Fire Marshal Division

Re: Red Barn Restaurant
123 E. Depot St.
Angier, NC 27501

Application Number FMFW2012-0003

# Ansul Pre-Engineered Fire Suppression System

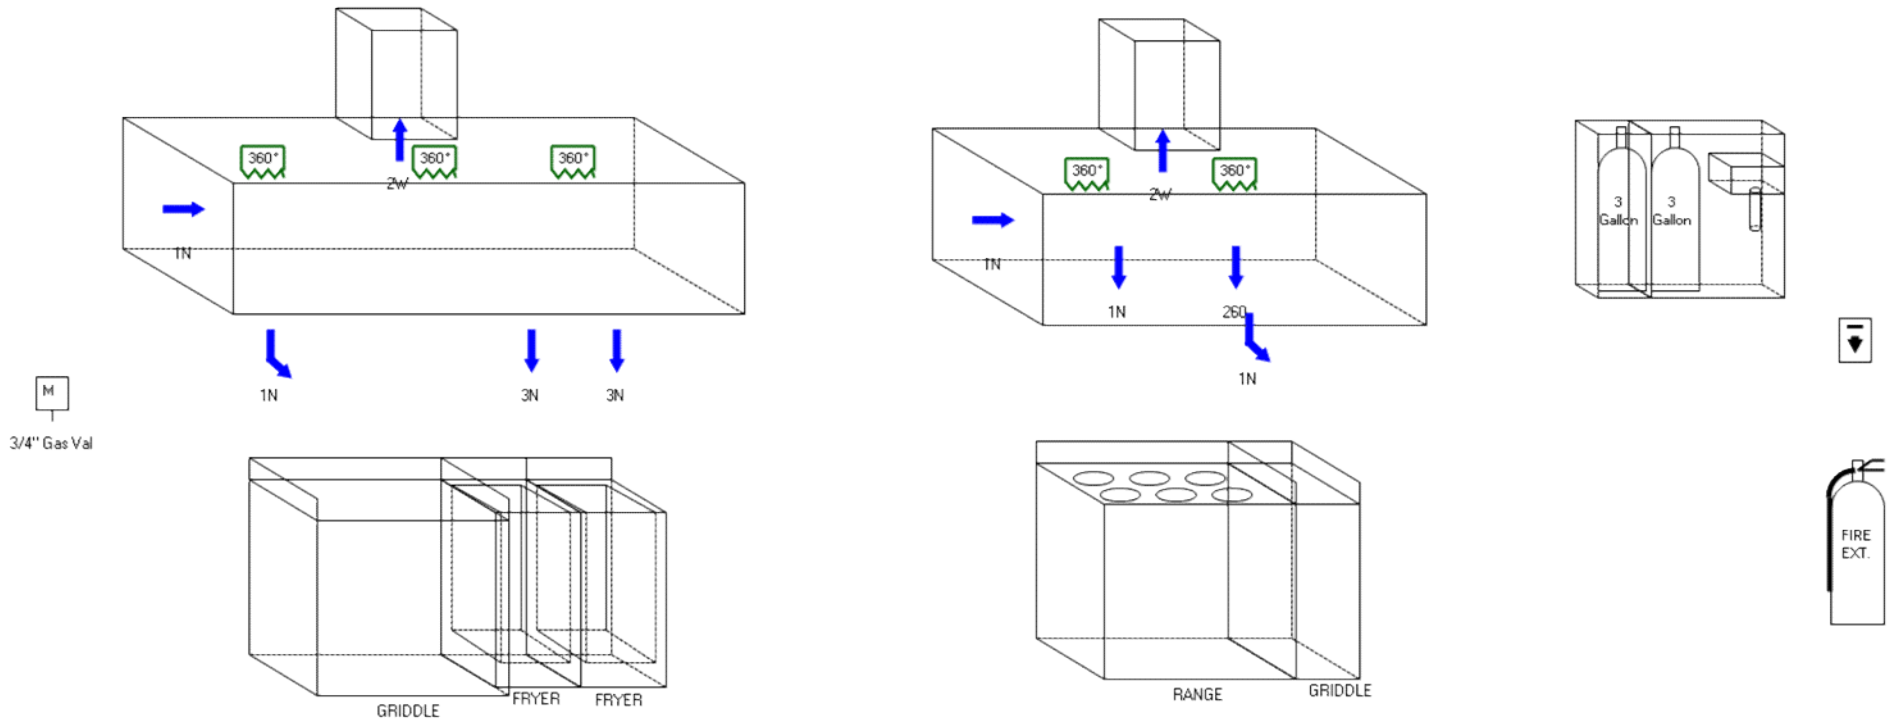
- **Commercial cooking equipment.**
 - Portable fire extinguishers shall be provided within a 30-foot (9144 mm) travel distance of commercial-type cooking equipment. Cooking equipment involving vegetable or animal oils and fats shall be protected by a Class K rated portable extinguisher.
- **Acceptance Test**
 - An acceptance test will be conducted by the Fire Marshal's office once system has been installed and pre-tested.
 - Installation shall be per architectural and system submittals and compliant with NFPA-17A.
- **Manual system operation**
 - A manual actuation device shall be located at or near a means of egress from the cooking area, a minimum of 10 feet (3048 mm) and a maximum of 20 feet (6096 mm) from the kitchen exhaust system. The manual

actuation device shall be located a minimum of 4.5 feet (1372 mm) and a maximum of 5 feet (1524 mm) above the floor. The manual actuation shall require a maximum force of 40 pounds (178 N) and a maximum movement of 14 inches (356 mm) to actuate the fire suppression system.

- The actuation of the fire suppression system shall automatically shut down the fuel or electrical power supply to equipment under the hood system. The fuel and electrical supply reset shall be manual.
